PL. AUTH. REF. 21772

AN BORD REF. ABP-313939-22

RE: EXTENSION OF SATELLITE QUARRY TO 13.6 HECTARES, CONSTRUCTION OF 40M CONCRETE TUNNEL UNDERPASS, AND CONSTRUCTION AND OPERATION OF NEW CONCRETE BATCHING FACILITY. PERMISSION IS SOUGHT FOR UP TO 20 YEARS. A NATURAL IMPACT STATEMENT (NIS) AND ENVIRONMENTAL IMPACT ASSESSMENT REPORT (EIAR) WERE SUBMITTED WITH THIS APPLICATION.  
CAPPAGH QUARRY, BALLYKENNEDY, KILGREANY AND CANTY TOWNLANDS, CAPPAGH, DUNGARVAN, CO. WATERFORD  
PLANNING REF NO 21/772

## REFERRAL SHEET FOR ENVIRONMENT

Figure 4-1  
Site Plan with Baseline Noise Monitoring Locations BN1 – BN5

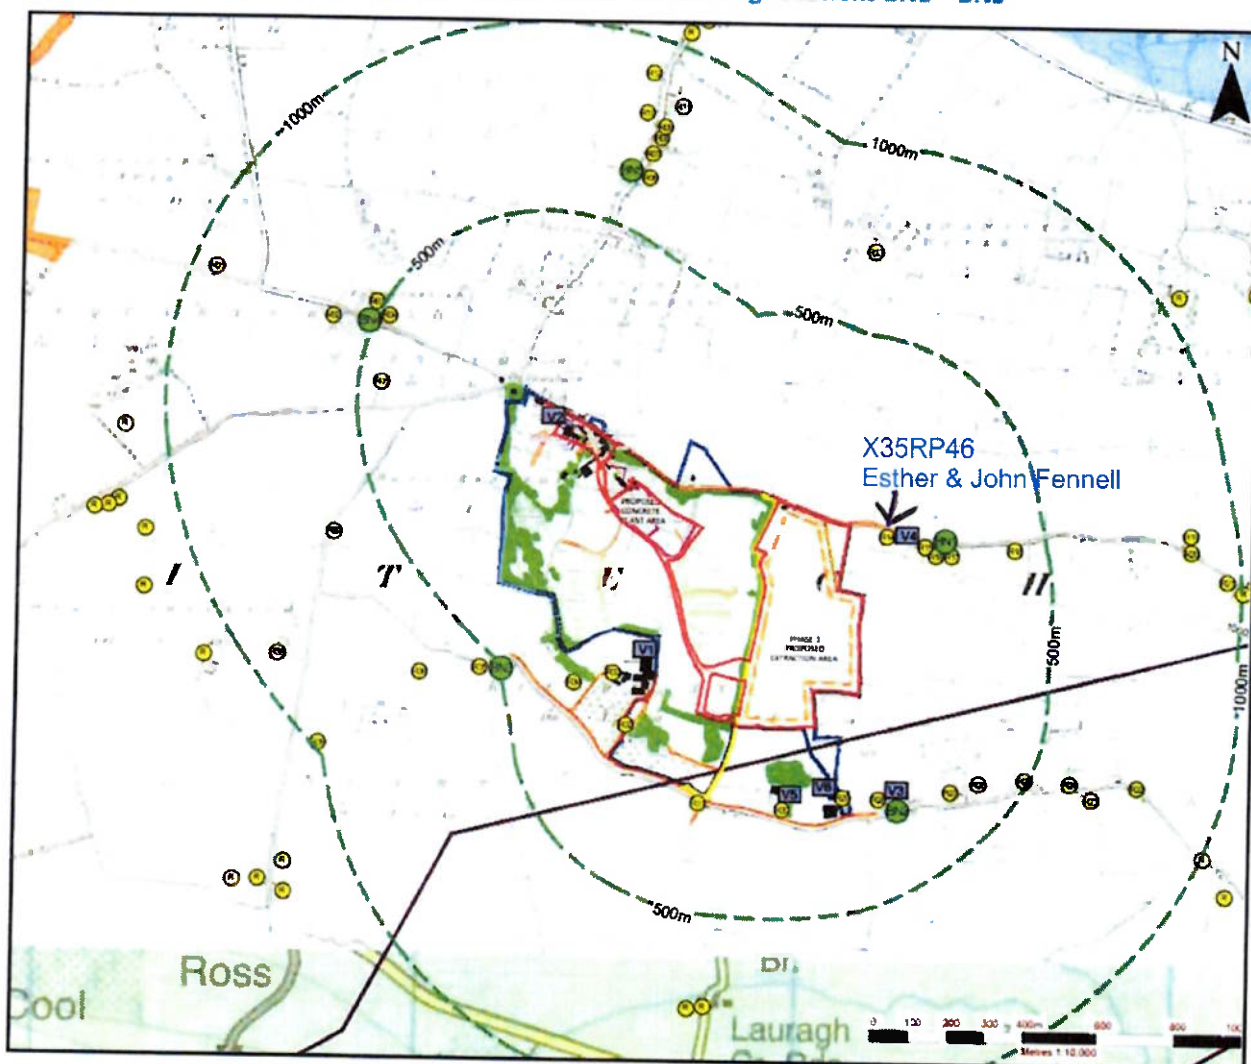
The additional noise monitoring point data which was assessed as part of the FI response was compromised due to nearby agricultural activity, but the applicant still sought to use that data to justify the higher noise level.

The applicant proposes using a noise level of 10dB above the background level as their limit, but according to BS4142, a noise level of 10dB above background is likely to indicate a significant adverse effect, with 5db indicating an adverse effect. Therefore I don't agree with the noise limits they propose.

1. Prior to the commencement of the development, the developer shall undertake an additional round of background noise monitoring at monitoring point BN5, as the information provided in the FI response was compromised by reported agricultural activity in the vicinity. This information shall be used to set a noise limit for residences in that vicinity.

3. The rated noise levels shall not exceed 5dB LAeq (1 hour) above the measured background noise level between 08:00 and 20:00 at any of the noise monitoring points. Where the noise predicted in the FI response is higher than that, the applicant shall propose enhanced mitigation measures for the agreement of the planning authority prior to the commencement of the development.

4. The developer shall install two continuous monitoring points at BN2 and one other location to be agreed with the planning authority to measure sound levels (LAeq (1 hour)). In the event that both these monitors show exceedances simultaneously for more than 5 individual 1 hour periods in a calendar month, the developer shall notify the Environment Section of Waterford City and County Council within one month, along with an narrative around the causes of the exceedance and proposed mitigation measures to ensure that the exceedance does not recur.
